MORGAN AND MORECAMBE OFFSHORE WIND FARMS: TRANSMISSION ASSETS

Technical Note: Landscape and Design Matters

Deadline: Deadline 3
7 July 2025

Document reference: S_D3_7

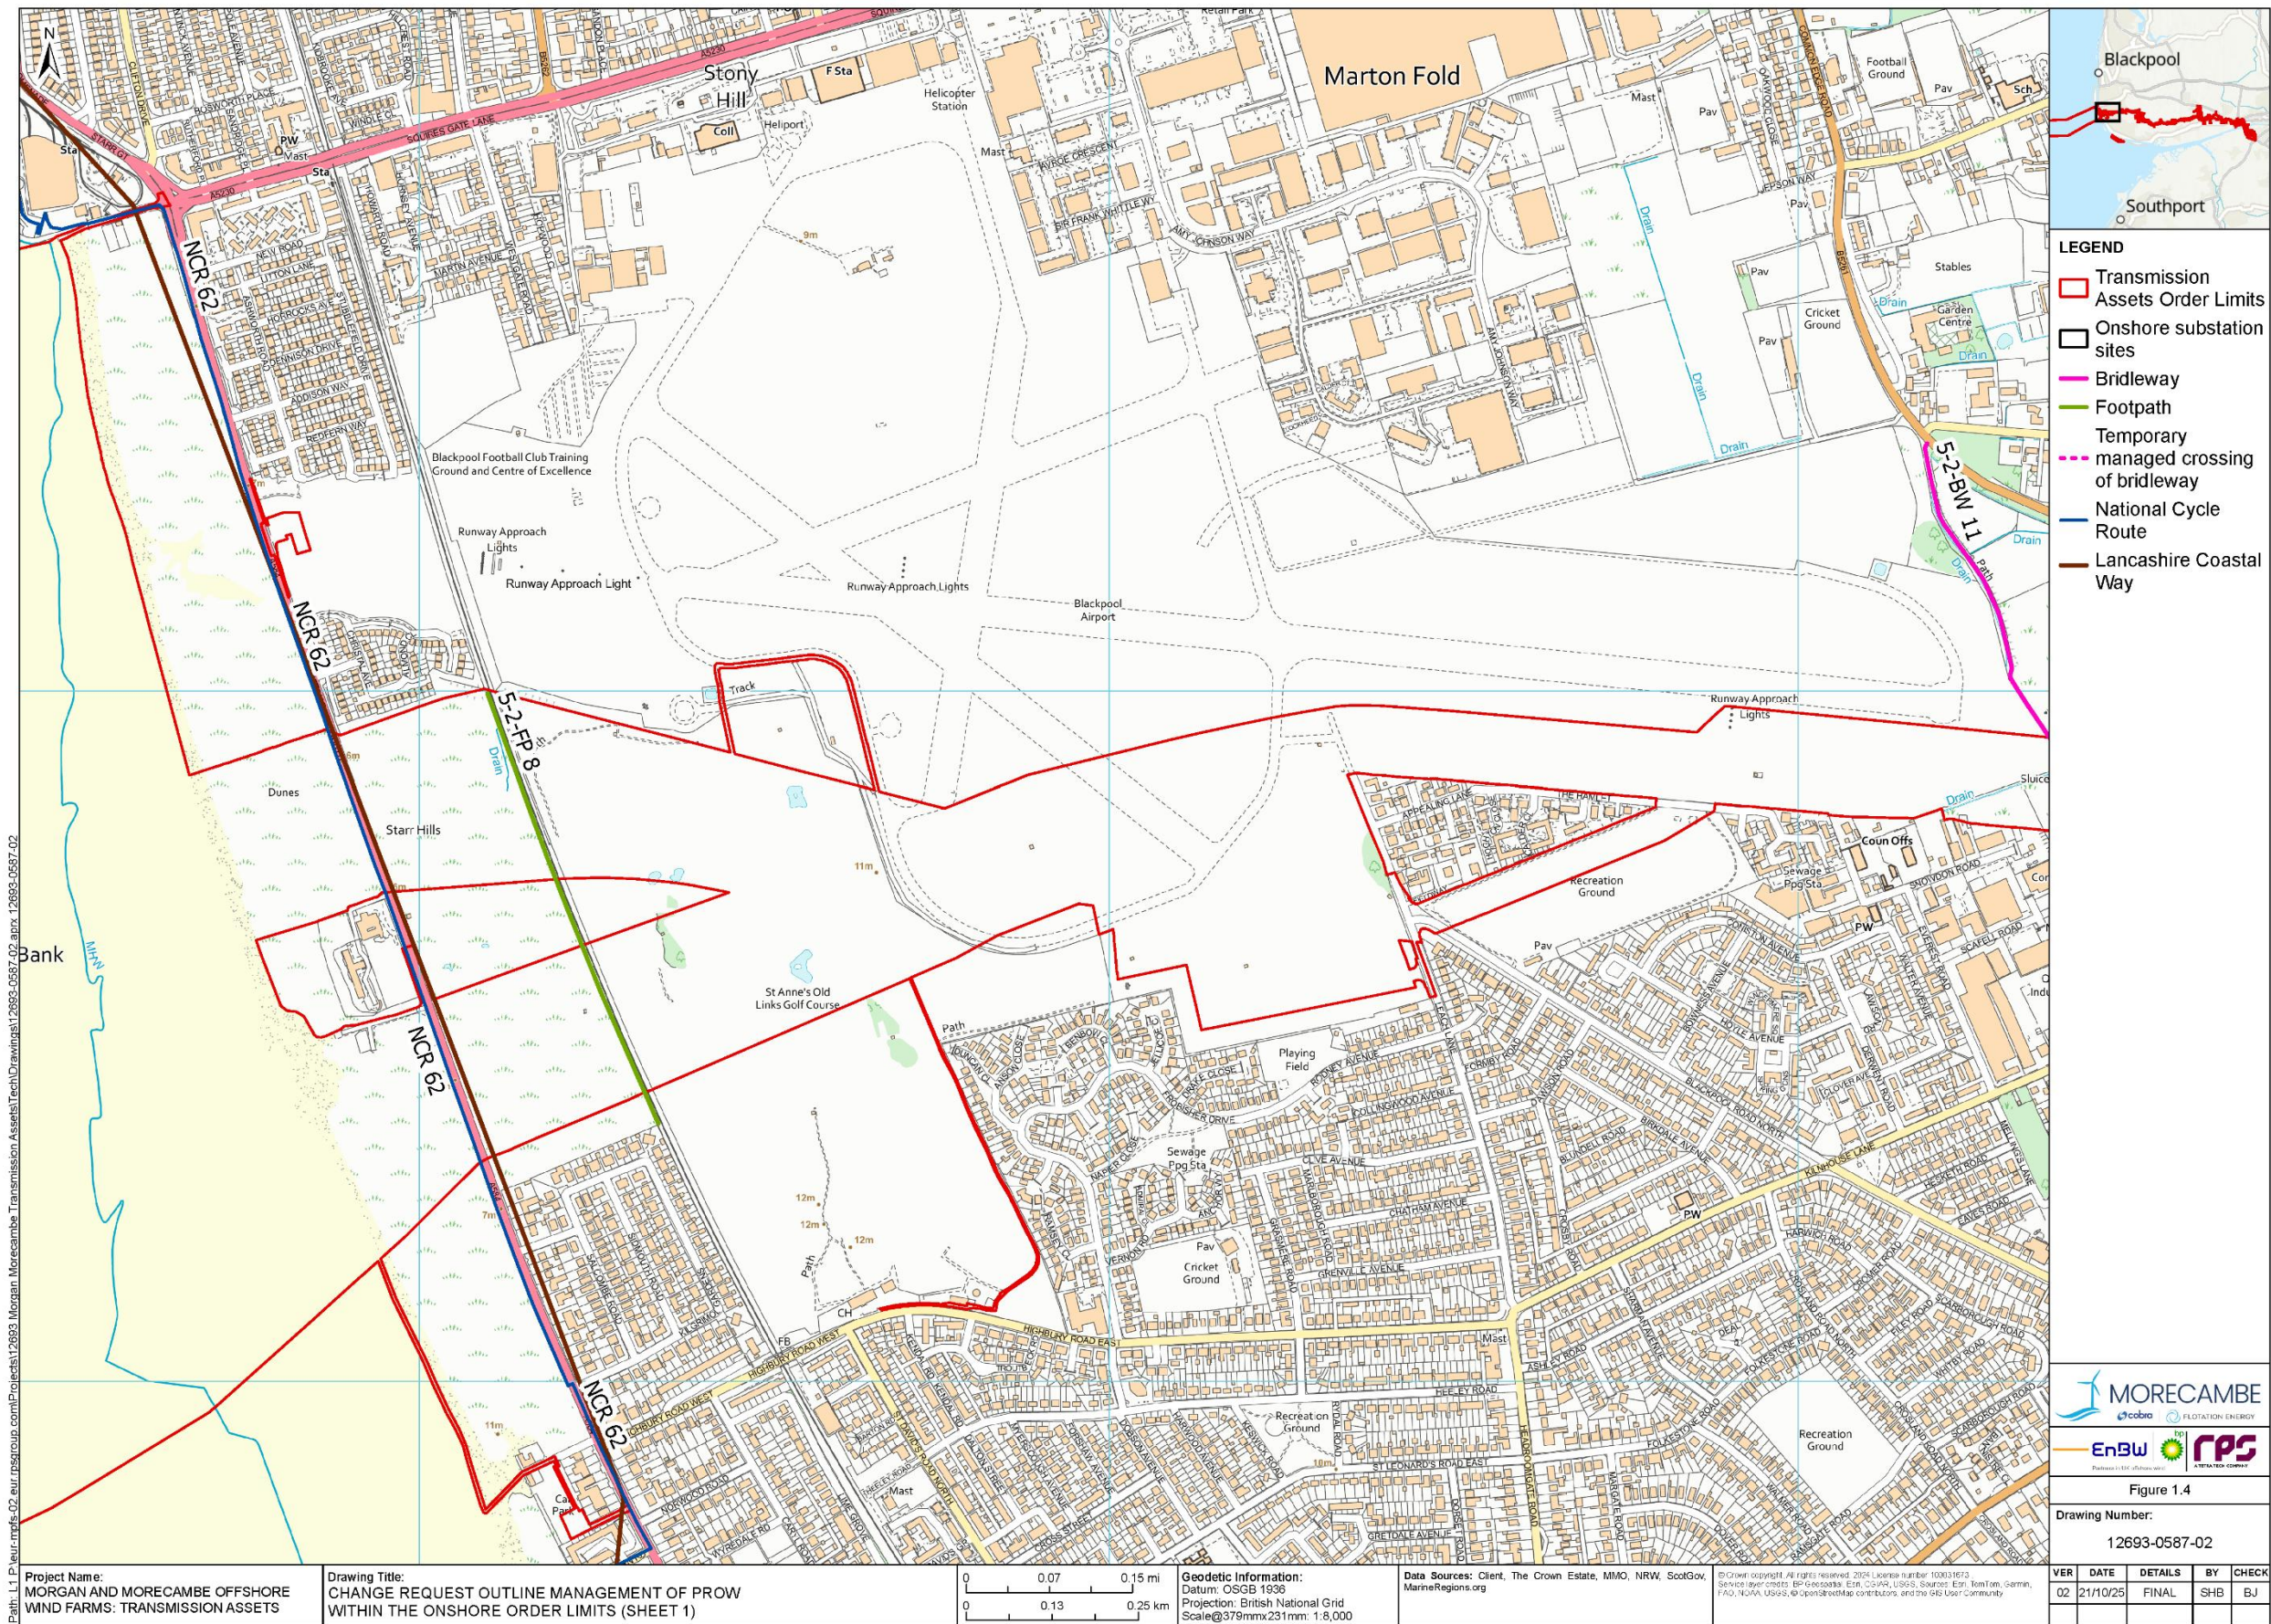
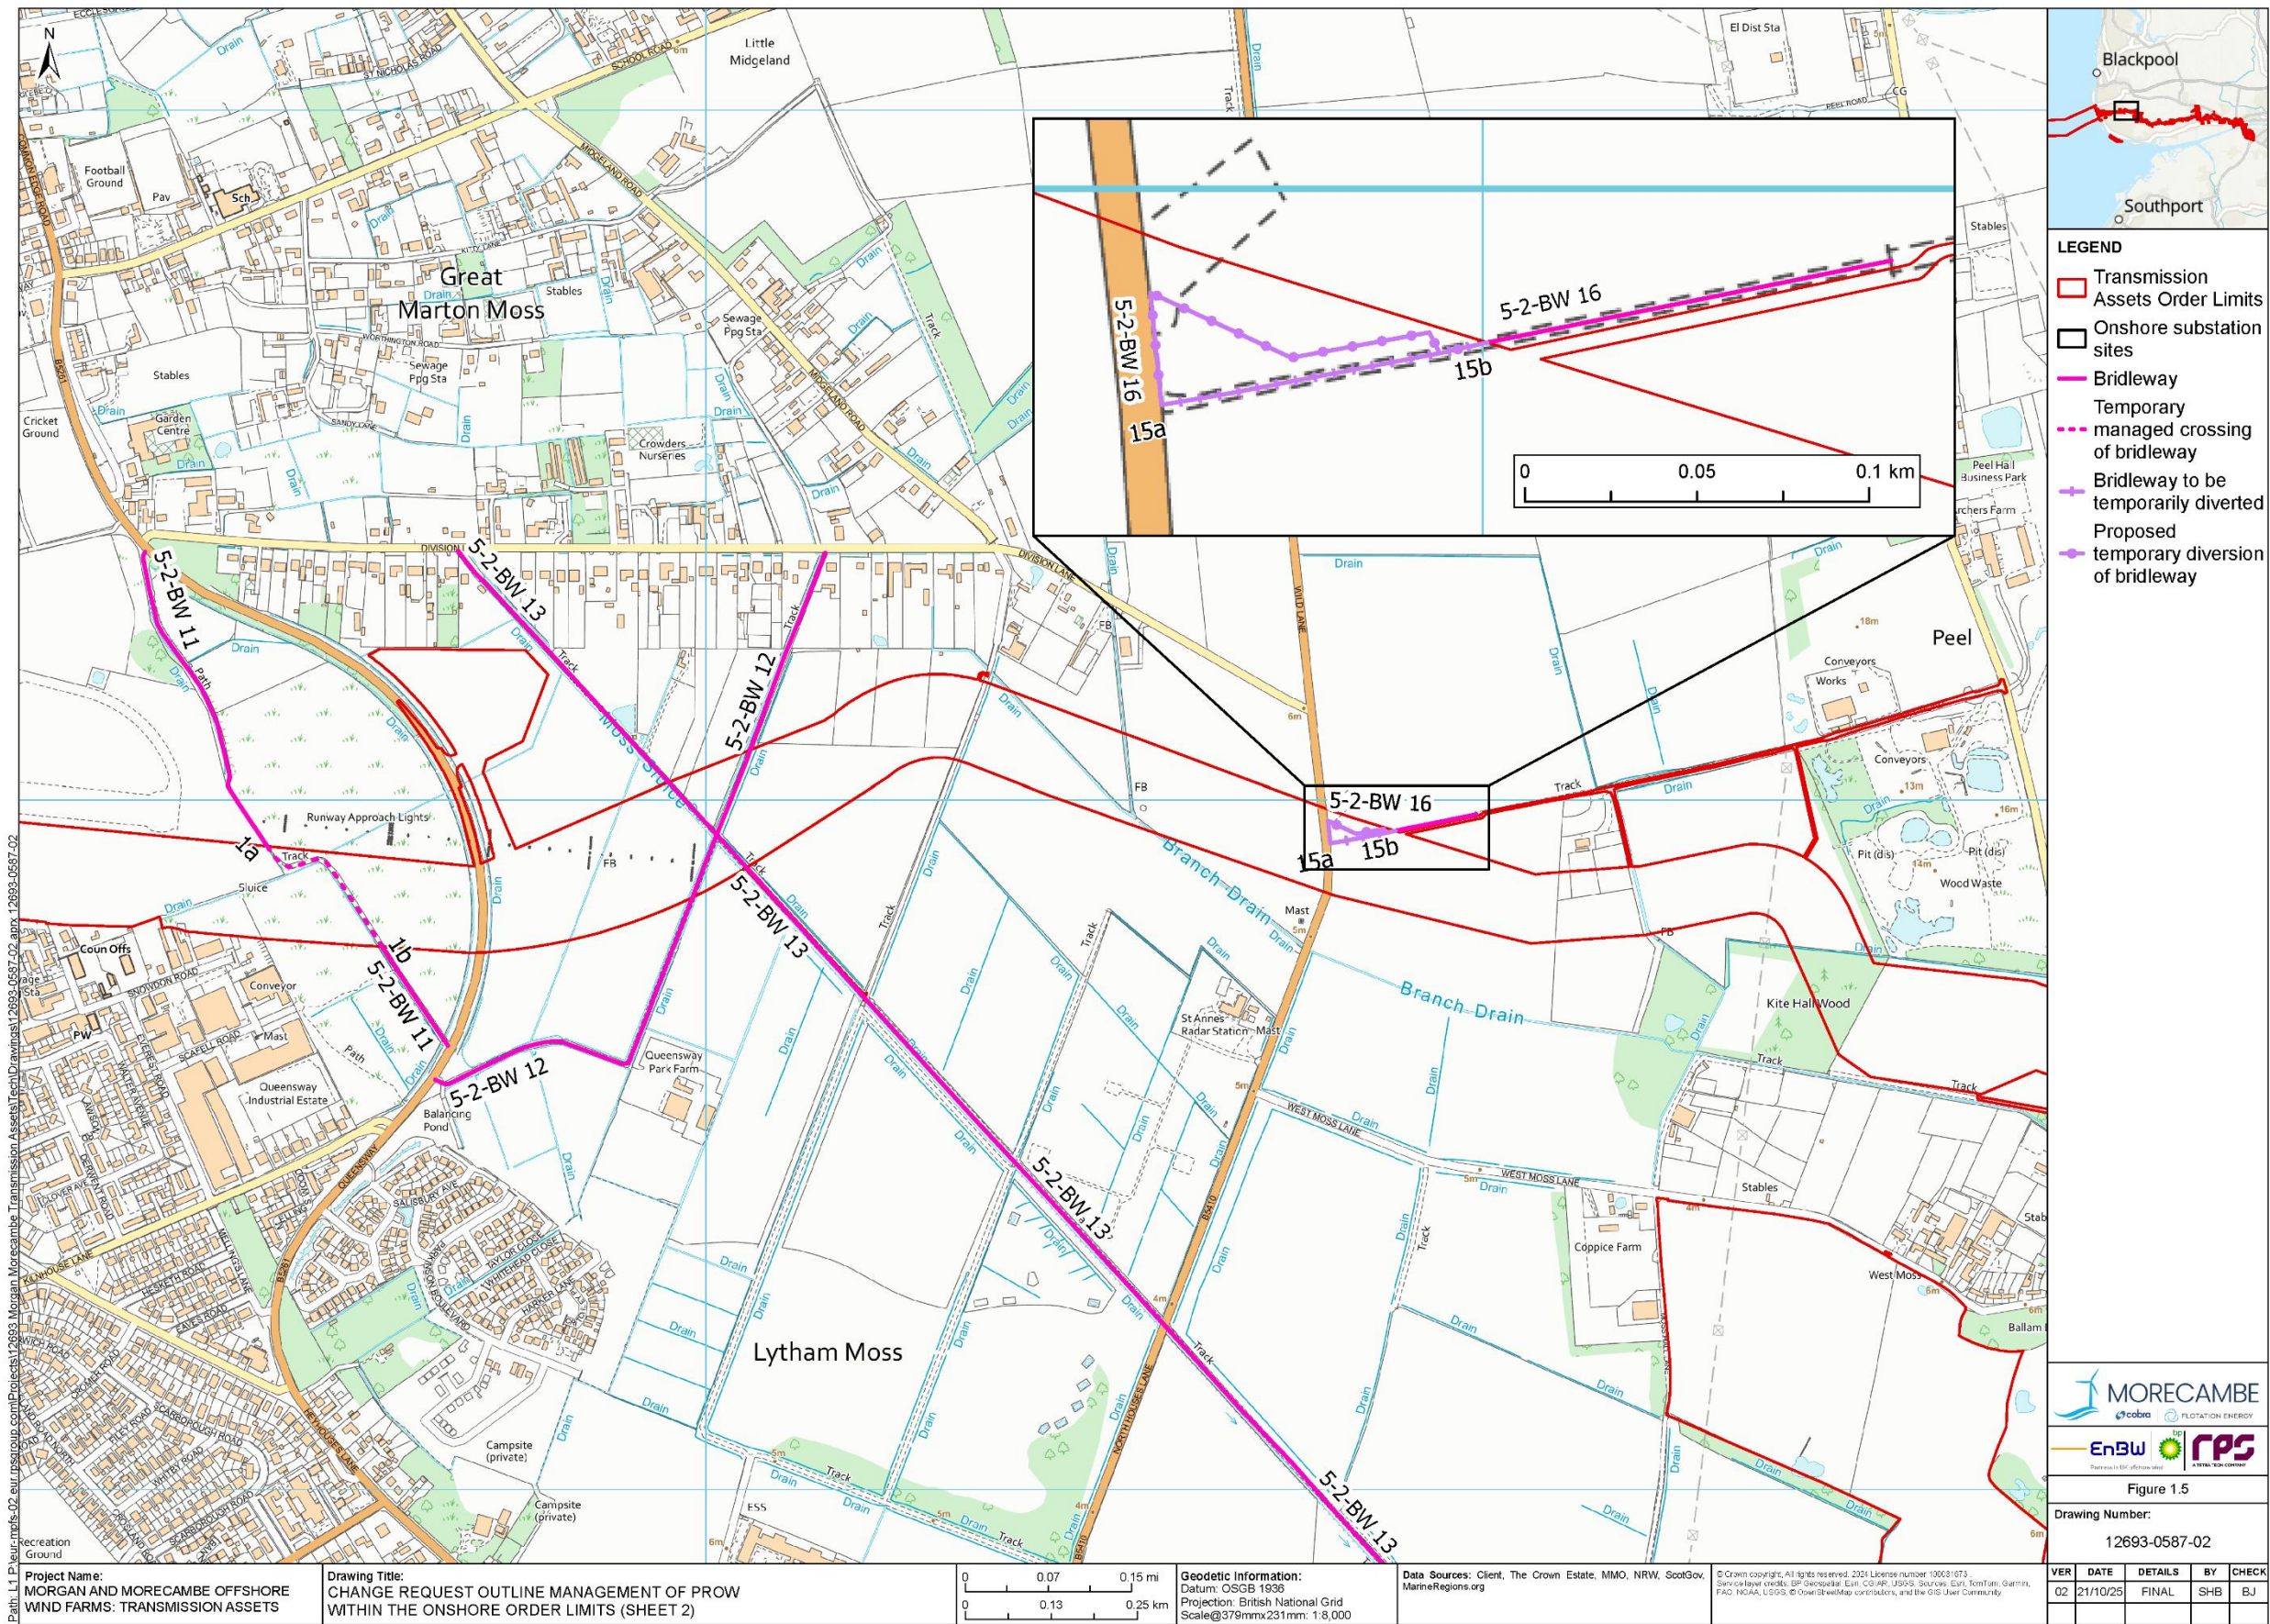
- 1.2.1.1 LCC LIR comment **REP1-085 7.49** raises concerns about the lack of detail in relation to the reinstatement of Public Rights of Way (PRoW) affected by the transmission works, particularly in relation to surfacing materials and demarcation, and requests clarity on how these will be restored, including features such as gates and signage.

- 1.2.1.2 The Applicants refer to the Outline Public Rights of Way Management Plan (AS-048), secured through Requirement 8 of the draft DCO (REP2-004) (dDCO). This Requirement outlines the principles for managing PRoWs during construction, making clear that detailed PRoW Management Plans will be developed and approved by relevant planning authorities, in consultation with stakeholders, before works commence. These plans will include specific information on surfacing and design, as confirmed in Section 1.5.8 of the Outline Public Rights of Way Management Plan (AS-048).
